TfNSW Reference: SYD15/01390/29
Departments Reference: SSD 7348 MOD 6

SECTION 4.55 (1A) MODIFICATION TO APPROVED OAKDALE WEST ESTATE - WAREHOUSE & DISTRIBUTION FACILITY - ERSKINE PARK

Kemps Creek, NSW

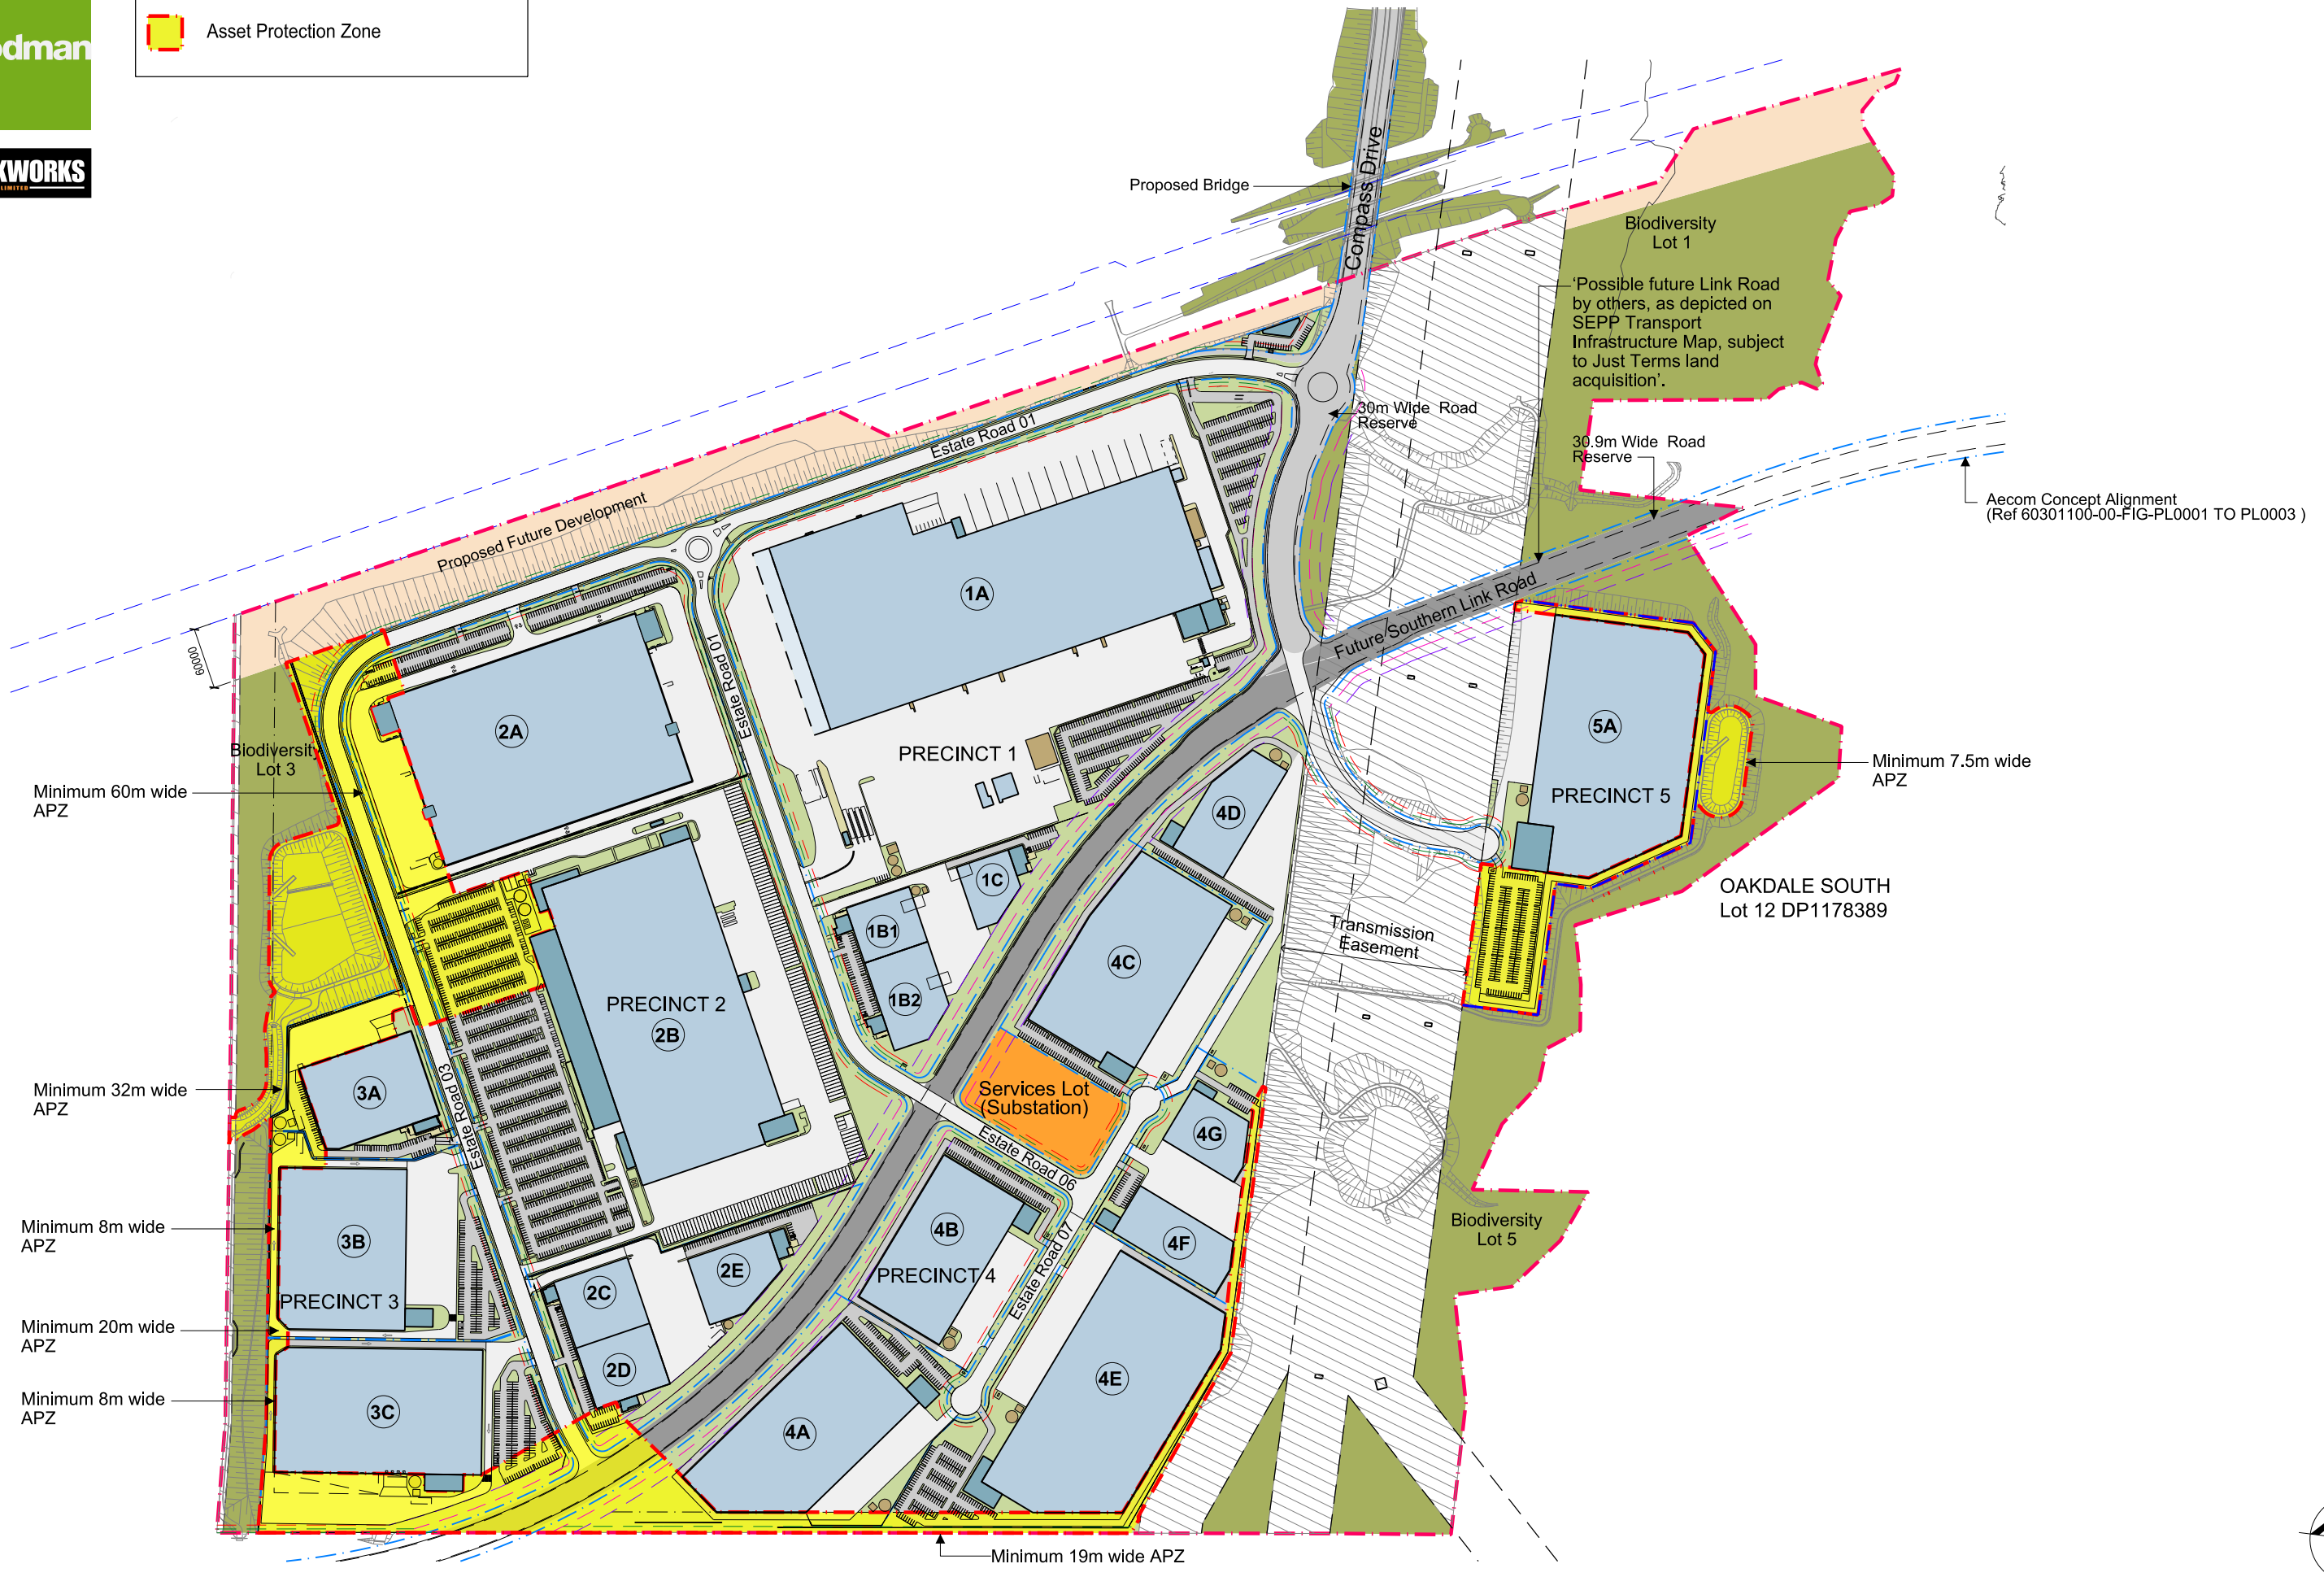
The lack of clear marking or labelling of the Gazetted Western Sydney Freight Line (WSFL) as SP2 on the maps makes it difficult to identify the impact on the proposed WSFL corridor.

TfNSW requests the maps be updated to identify the Gazetted Western Sydney Freight Lines as SP2 for clarity.
